Our Ref: JH/10622/jj

25 September, 2019

**RE: ST ANTHONY OF PADUA CATHOLIC SCHOOL AT AUSTRAL
STATE SIGNIFICANT DEVELOPMENT APPLICATION FOR
SCHOOL MASTERPLAN**

ELEVENTH AND FOURTH AVENUE INTERSECTION				
SCALE: AS SHOWN	DRAWN: P.M.	DESIGNED: P.M.	CHECKED: L.Sh.	APPROVED: M.C.
JOB No. 5914000		DRAWING No. C5.08		ISSUE 1
DATE MARCH 2018	STATUS DEVELOPMENT APPLICATION

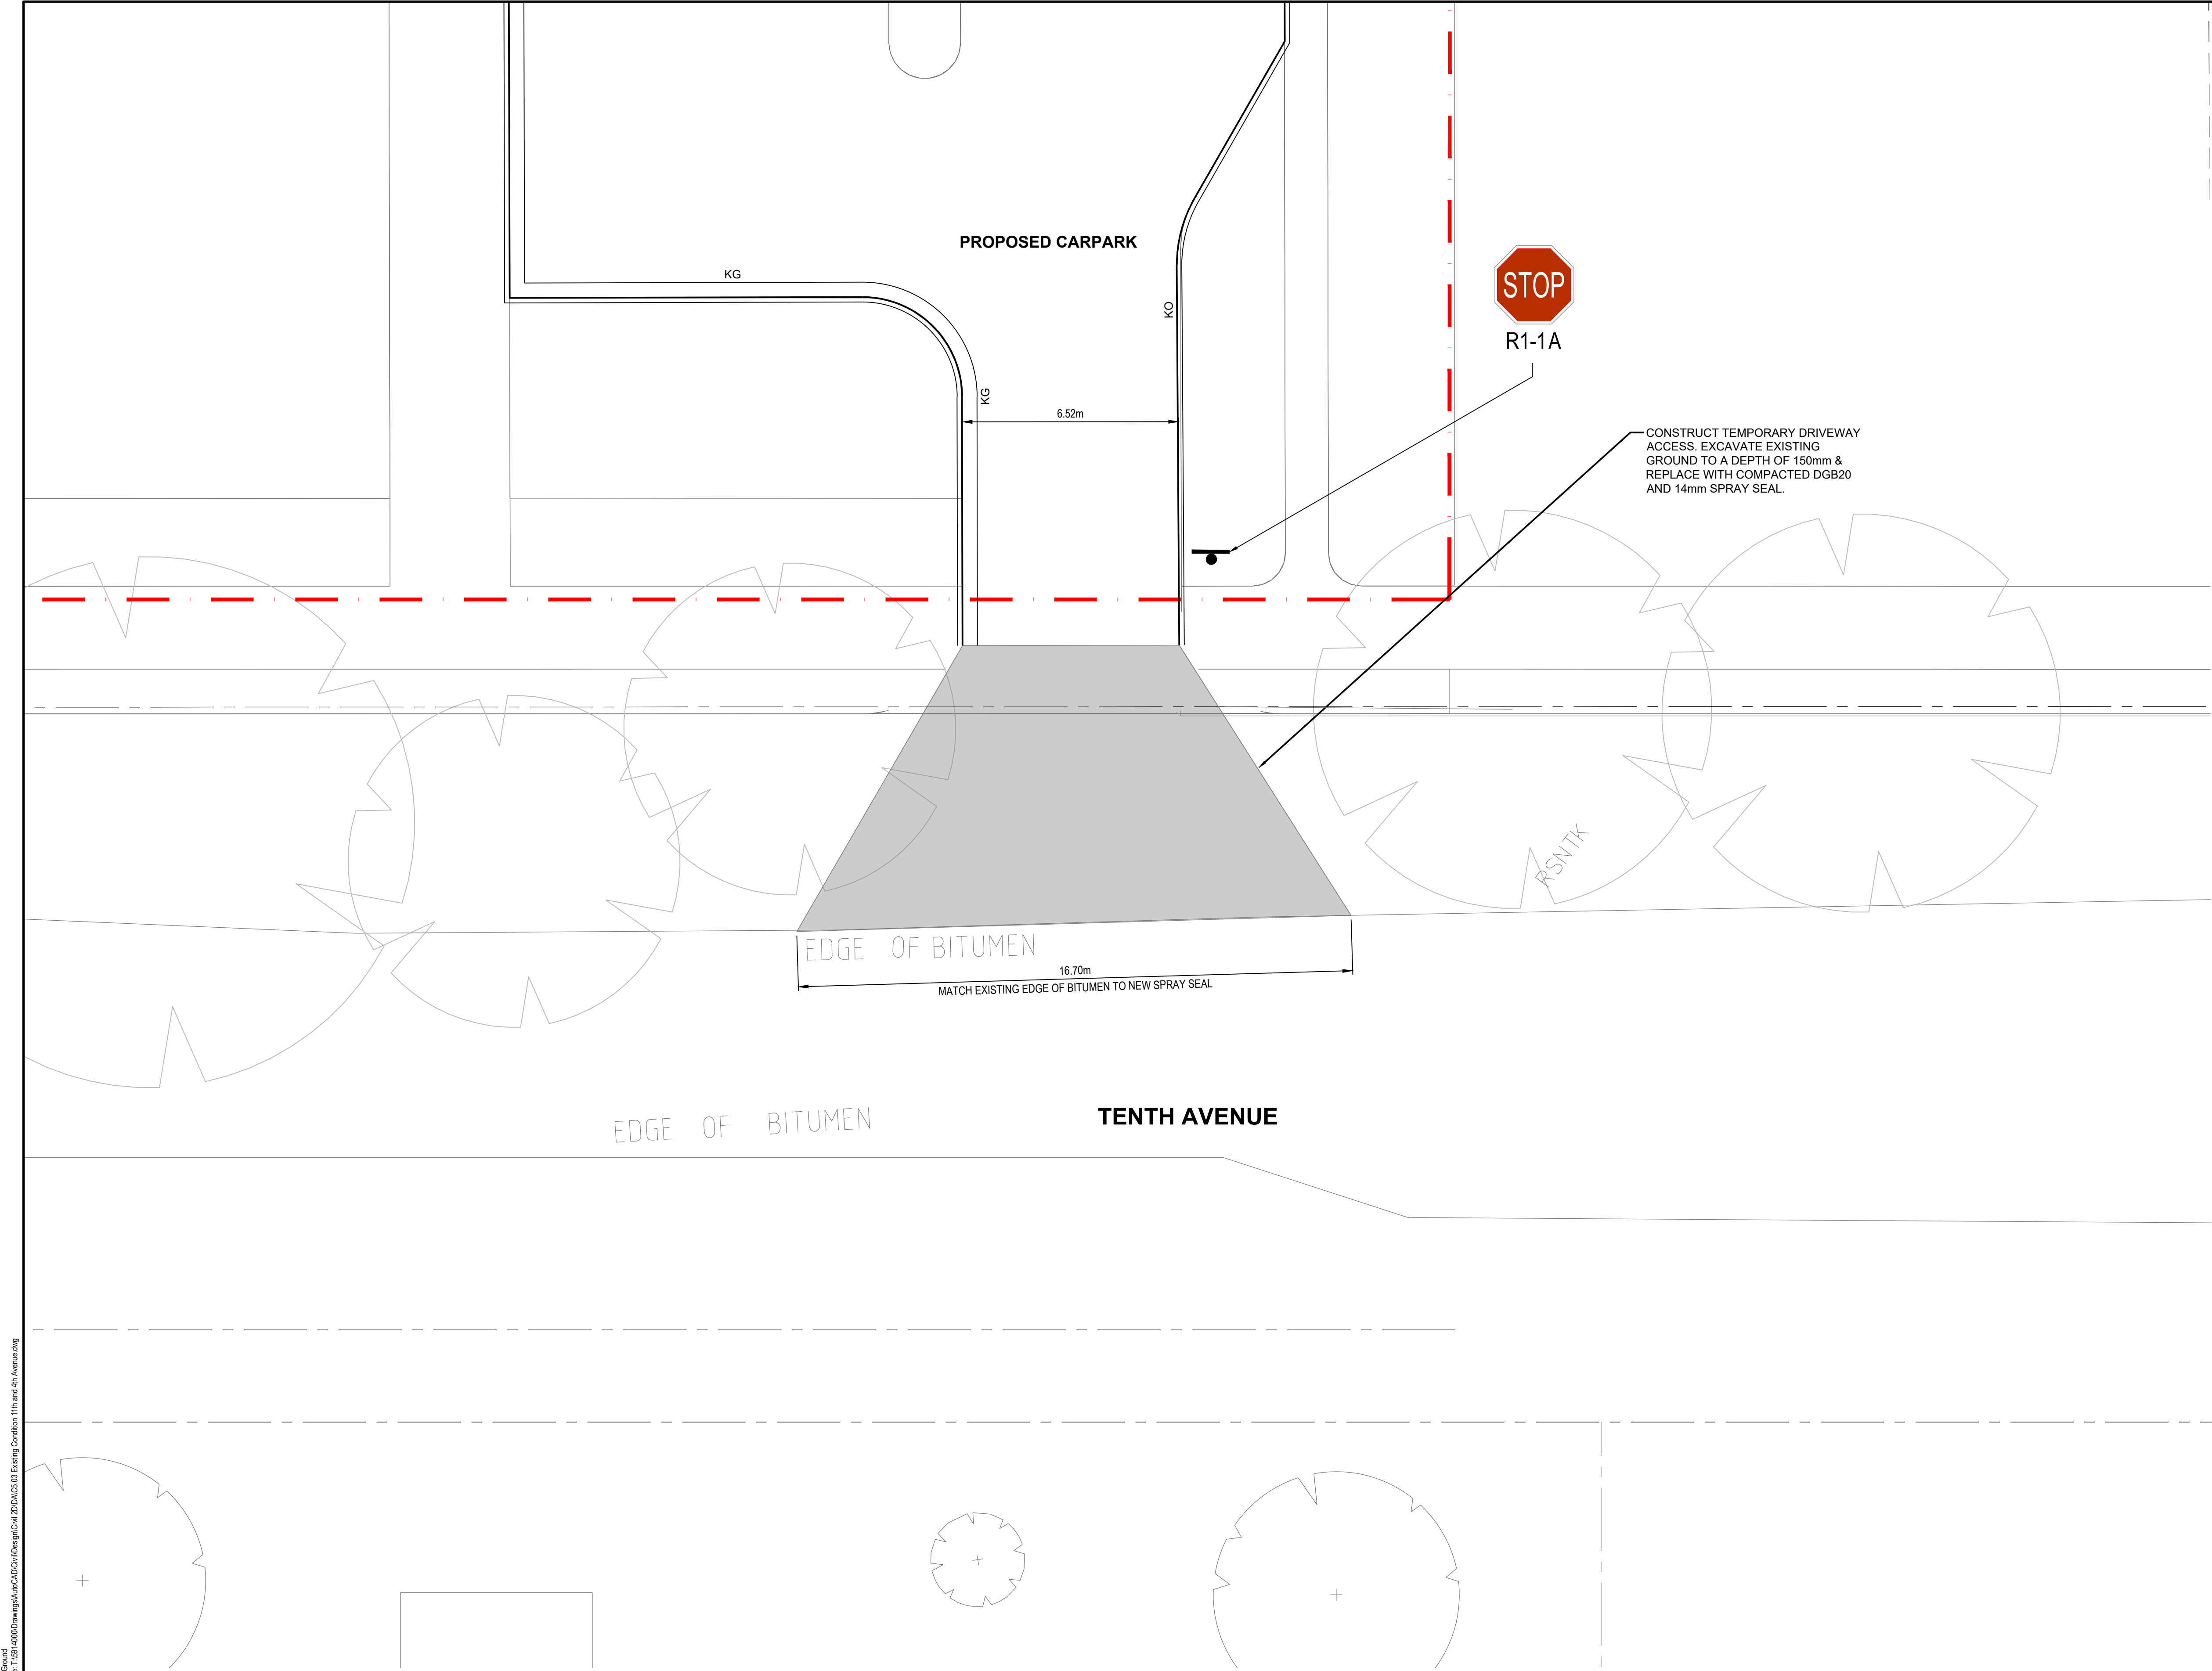
- *The revised scheme proposes to delete road infrastructure upgrades including signalised intersections and pedestrian crossings without any clear commitment as to how the intersections would be treated or infrastructure delivered in the future. There is no additional assessment of the interim and long terms traffic impacts as well. As part of its assessment of the application for a traffic generating development, the Department must understand and assess the traffic impacts of the proposal including an assessment of measures to mitigate those impacts. Consequently, a revised detailed traffic assessment is required, demonstrating the likely traffic movements, impacts to the operation of the local road network, pedestrian and cyclist movements and safety for each sub-stage of the proposal. The assessment should inform road upgrades and mitigation measures necessary to offset assessed impacts and ensure appropriate levels of service and safety at each sub-*

8. The RMS correspondence is provided as Attachment 3.
 - *The Department notes that the Growth Centre DCP for this precinct requires roundabouts at the intersection to the west of the site. The draft RTS does not clarify why this option has not been considered instead of the signals, in the scenario that an alternate upgrade is proposed.*

- iii) at Stage 3 of the school (enrolments of some 1,150) road widening works to be undertaken on Tenth Avenue, Eleventh Avenue and Fourth Avenue, adjacent to the school, including bus bays. Provision to be included for intersection treatments (roundabouts with pedestrian refuges or traffic signals) at the intersections of Fourth Avenue with Tenth Avenue and Eleventh Avenue at this time. Financial contribution to be made to council for construction of these works, at Stage 1. Marked pedestrian crossings to be provided on Tenth Avenue and Eleventh Avenue at this time (to replace school crossing on Eleventh Avenue if not already provided). All works subject to traffic committee/RMS approval.

9. Figure 2-12 (Precinct road hierarchy) of Schedule 1 (Austral and Leppington North Precincts) of the Liverpool Growth Centre Precincts DCP 2013 (Attachment 4) does not identify roundabouts at the intersections of Fourth Avenue with Tenth or Eleventh Avenues. However, as noted above, roundabouts will be provided at these intersections in association with Stage 3 of the school, when enrolments reach some 1,150.

1 SITE PLAN - STAGE 1
1 : 1000

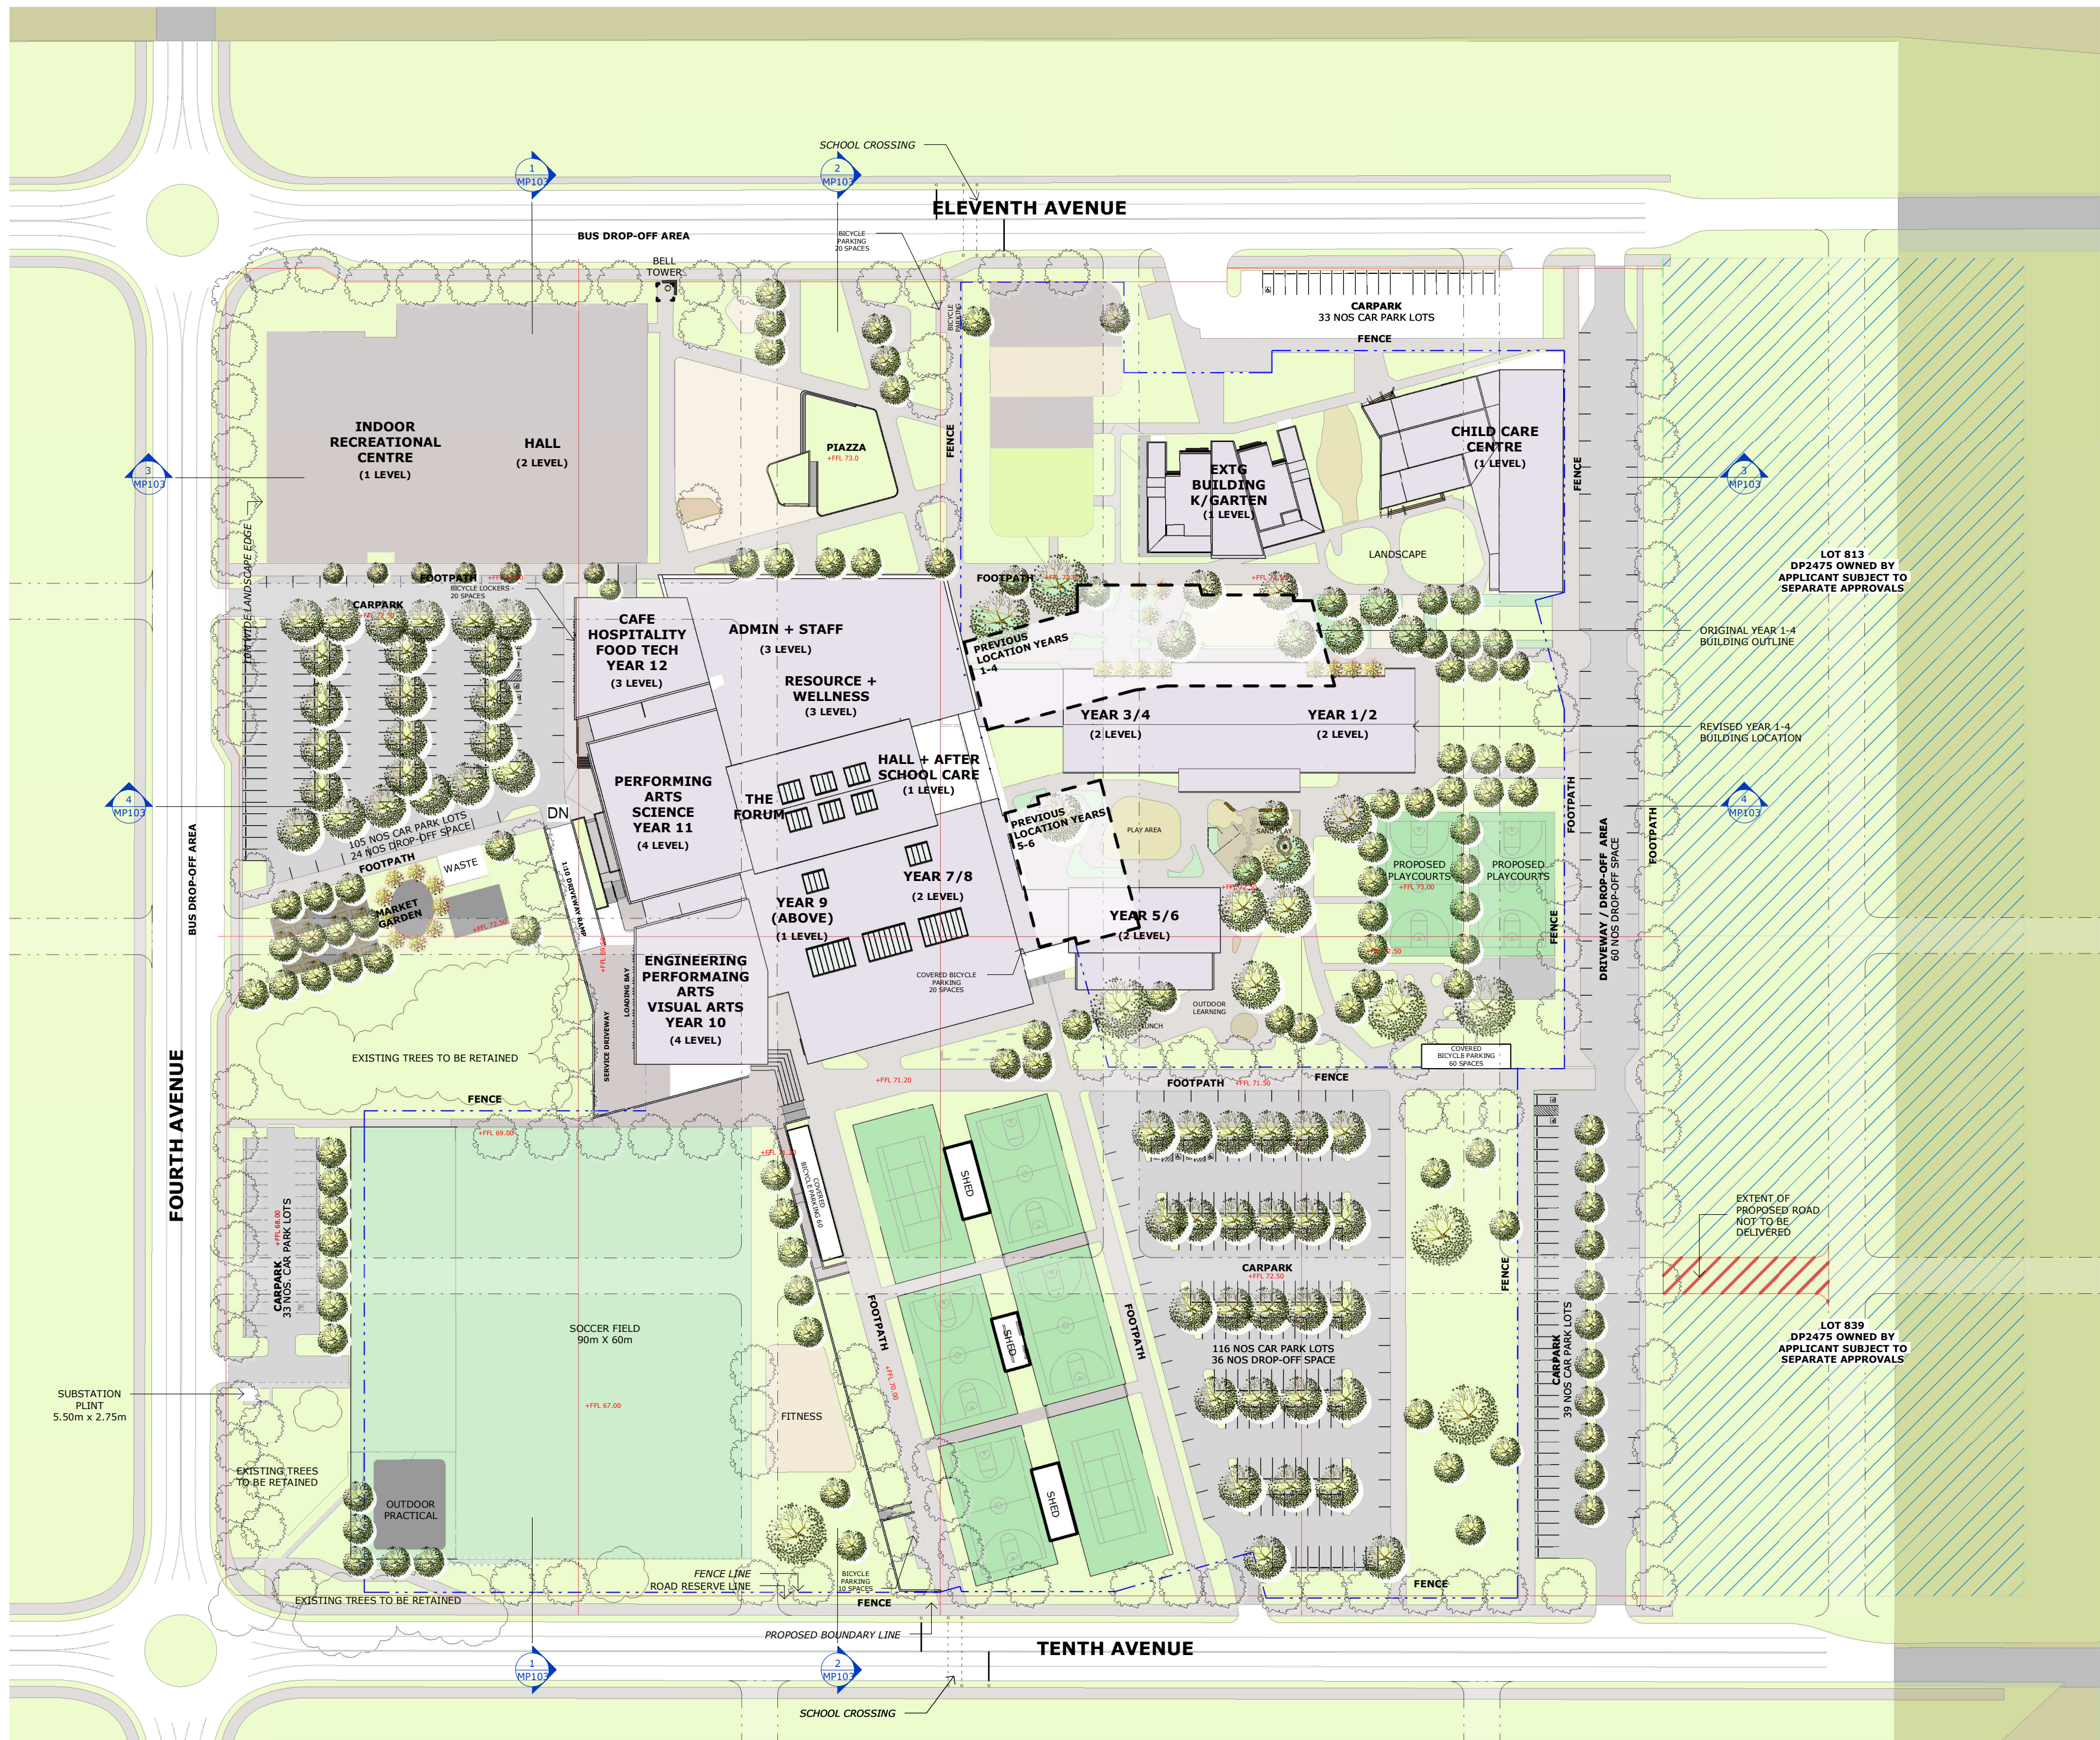
- *The proposal in its current form would only provide for half of the road widening within the site and relies on other land owners to construct the remaining half. This requirement would burden a Council owned part and private residential allotments. There is no evidence of a road widening easement at these locations. Consequently, the proposal cannot rely on these allotments without any owners' consent for the effected land owners consenting to this encroachment. The proposed road widening is not supported in its current form by the Department. The site plan is to be amended to allow the entire widening to occur within the site and the development envelope adjusted to cater for this widening.*

- *The school boundary should also be adjusted so that public footpaths and required verge landscaping are outside of the school boundary – noting in some cases the current plans show them within the school boundary.*

24. All land required for road widening will be provided from the school site. The civil and architectural plans have been amended to more clearly reflect this aspect.

25. The amended civil and architectural plans incorporate these elements.
- *The Department strongly recommends meeting with both Council and RMS to agree on road infrastructure and traffic management measures, delivery and finding arrangements prior to submission of the RTS.*
